From: [Downes, Scott G \(DFW\)](#)
To: [Jeremiah Cromie](#)
Cc: [Torrey, Elizabeth M \(DFW\)](#)
Subject: RE: RU-22-00005 Kostenich - Notice of Application WDFW Comments
Date: Monday, November 28, 2022 9:37:11 AM

Thank you for sending out for review. There are a couple of items that WDFW believes should be in the application prior to review or approval:

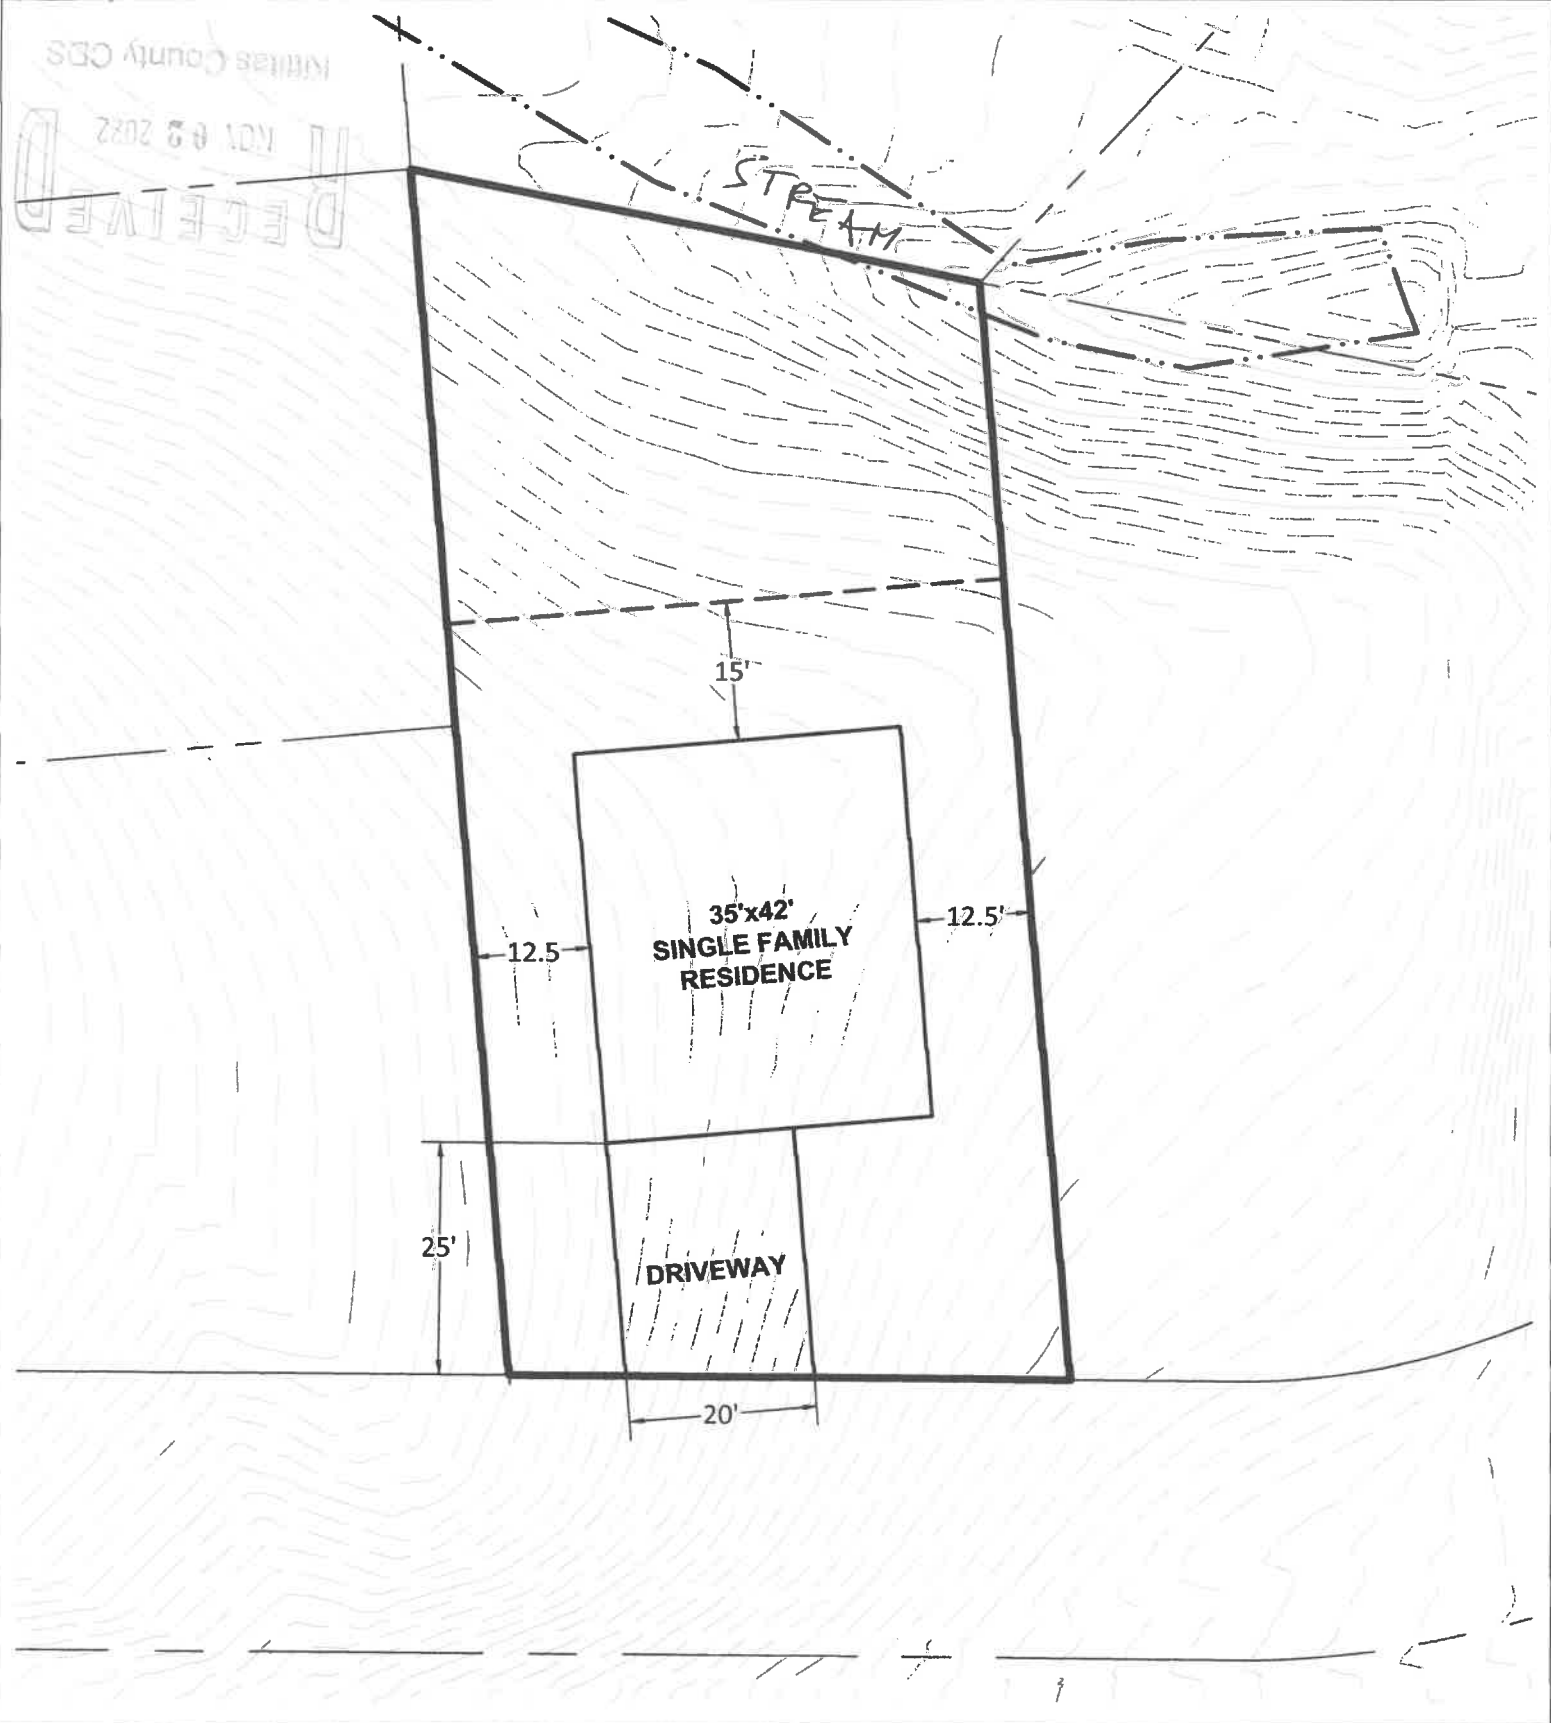
1. The applicant does not show on his site plan the distance to the stream edge to allow for comment on how far proposed setbacks from the creek would be. WDFW would like to see this distance prior to any approval and before the comment deadline in case we may need to make further comment.
2. The applicant should be submitting a mitigation plan for potential impacts to the riparian area from encroachment due to the building. That mitigation plan should include strategies to offset any loss of riparian function from vegetation (trees, shrubs) lost from the clearing. Once a mitigation plan is prepared, WDFW would like to review and comment and if necessary meet on site to discuss prior to approval of a mitigation plan. WDFW requests that this mitigation plan be a condition of an approval.
